**Re: Juan Tabo Hills Unit 3A
DRB 1007139**

With this resubmittal I have made the following revisions to the DRB preliminary plat, site plan, grading plan and vacation requests:

**PRELIMINARY PLAT FOR JUAN TABO HILLS, UNIT 3A**

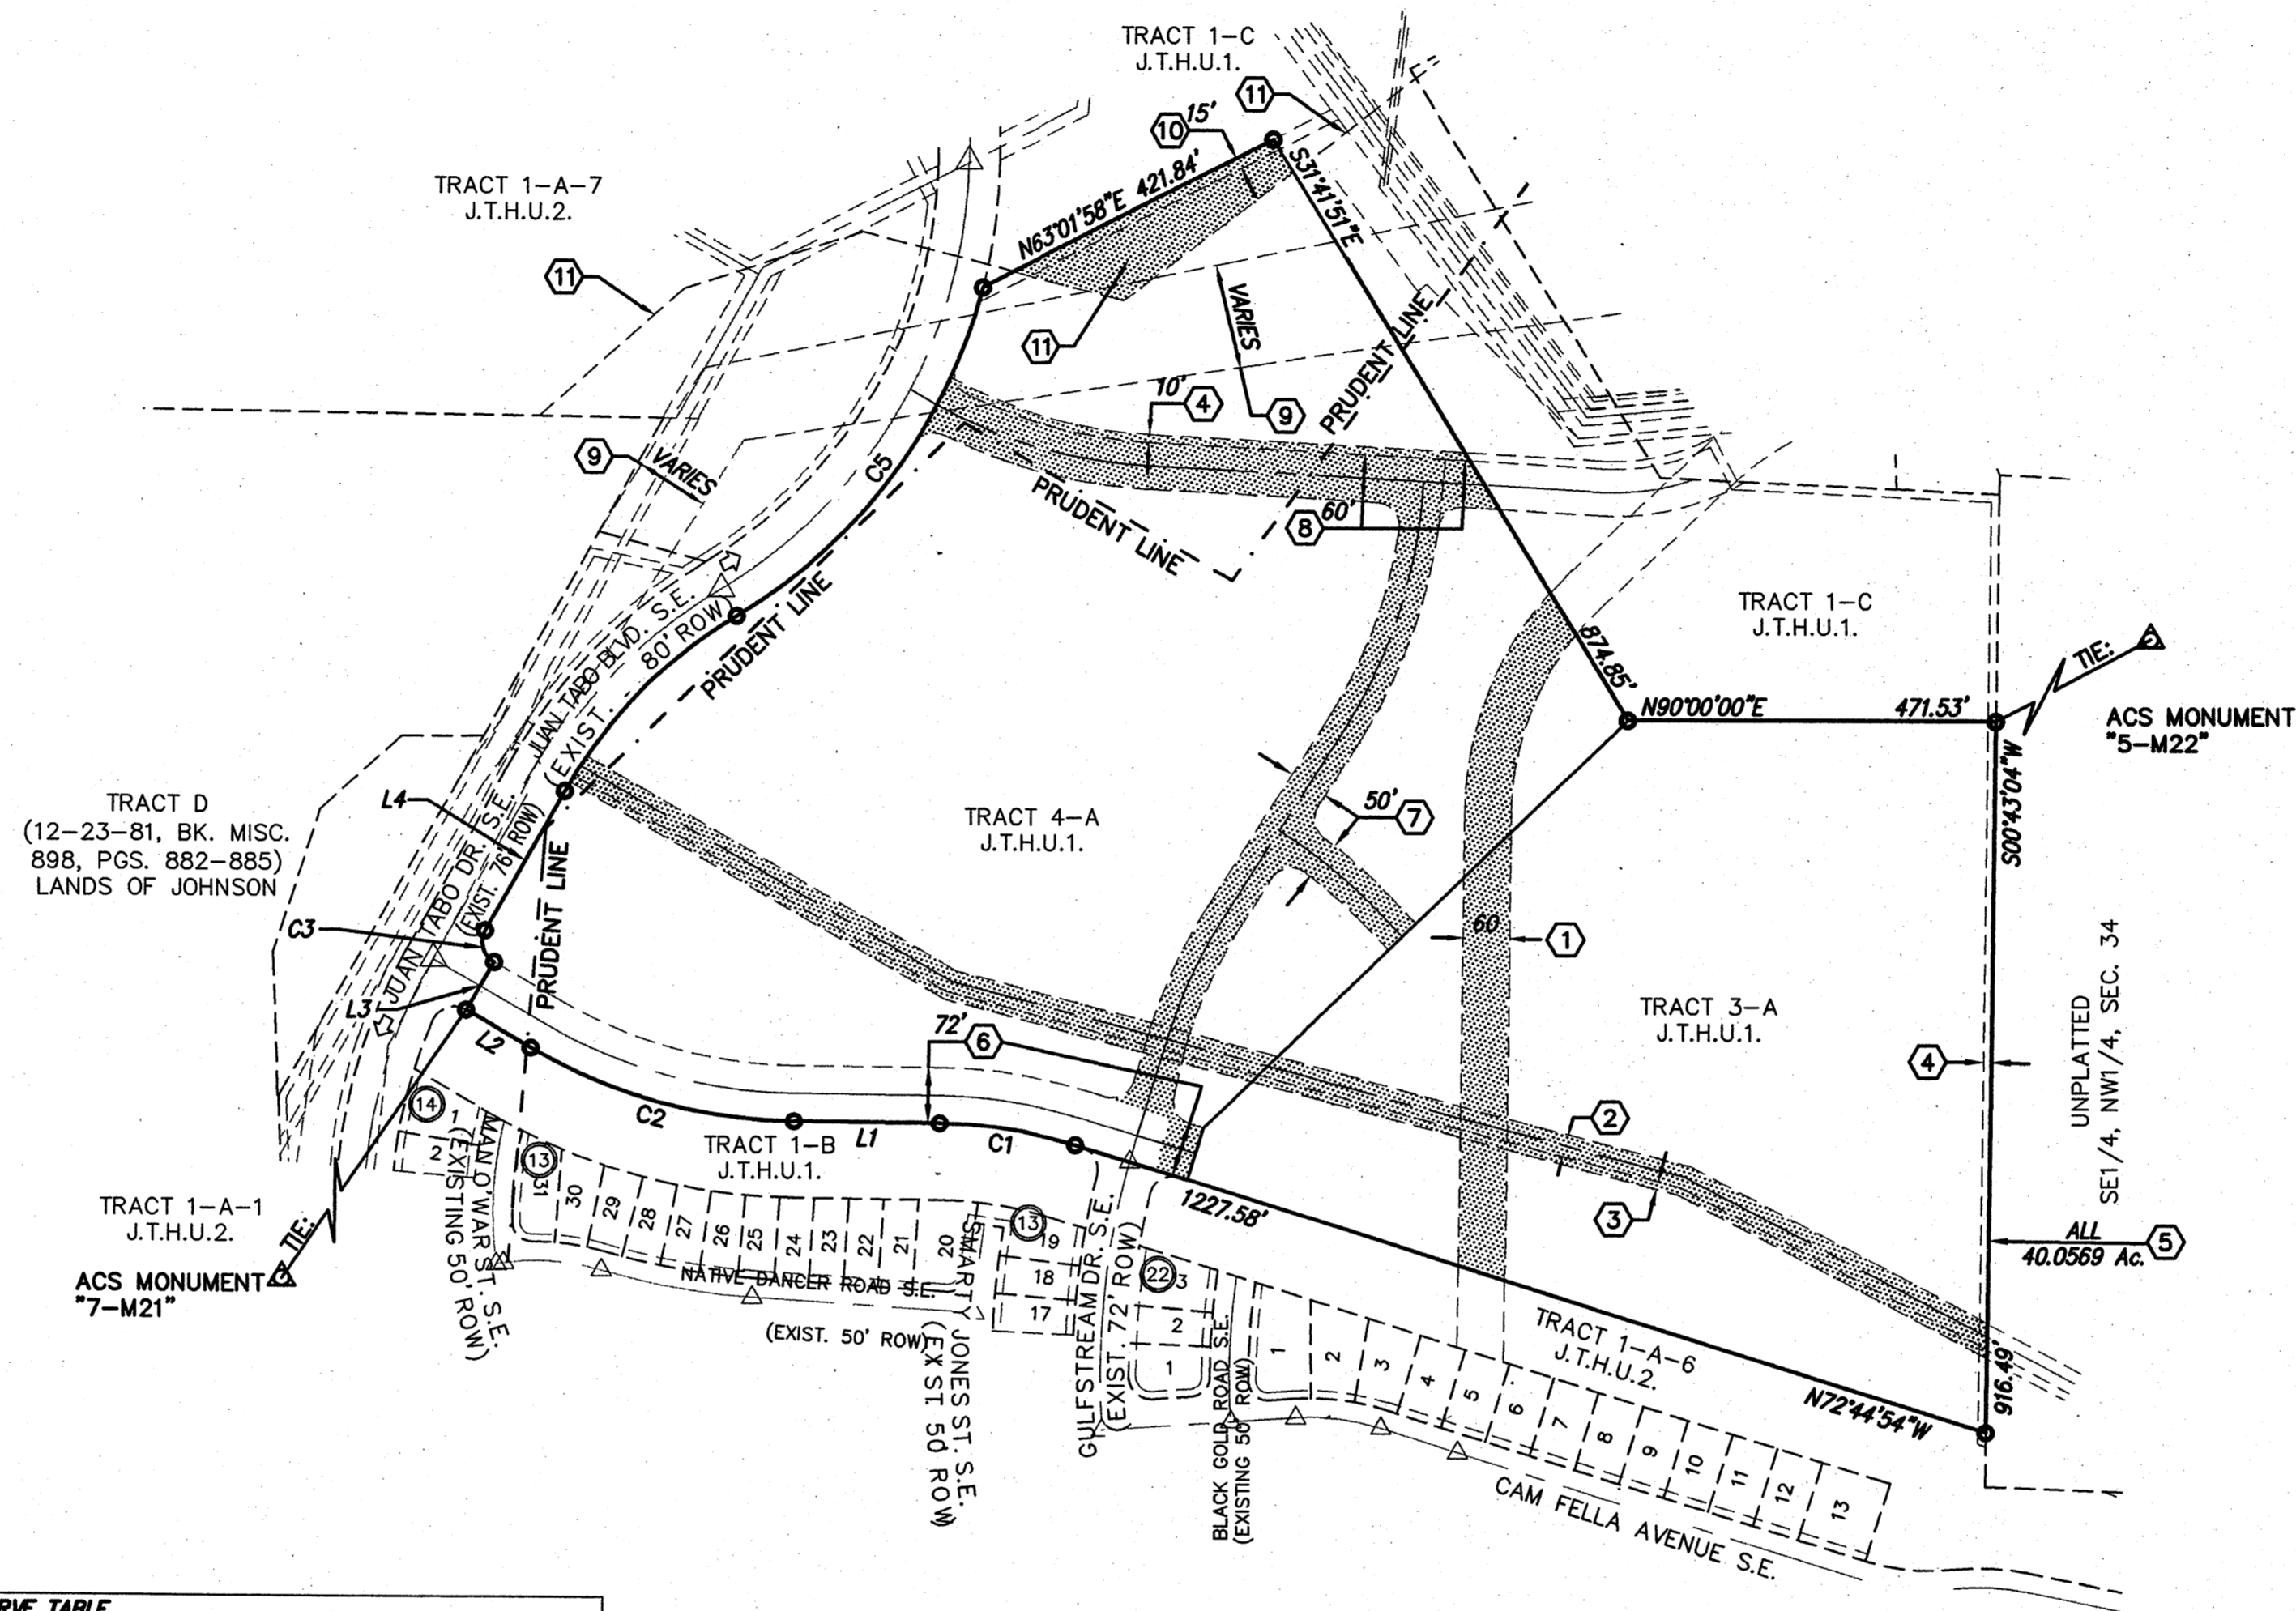
PRELIMINARY PLAT

1. renamed Via Posada to Monachos Road,
2. vacating all of Gulfstream Drive and Monachos Road (formerly Via Posada) and rededicating a revised alignment,
3. granted new alignment for Gulfstream Drive to include public utilities,
4. granted new alignment for Cavalcade Ave.,
5. granted a 25' public sanitary sewer easement through Tract 4-A-1,
6. Listed the purpose and maintenance responsibilities for the 4 Tracts in Unit 3A under Notes,
7. Extended the R/W into Lot 23, Block 1,
8. removed the sanitary sewer easement on Lot 23,
9. realigned offsite sanitary sewer through Tract 1-A-6
10. The site plan was revised to reflect the appropriate changes.
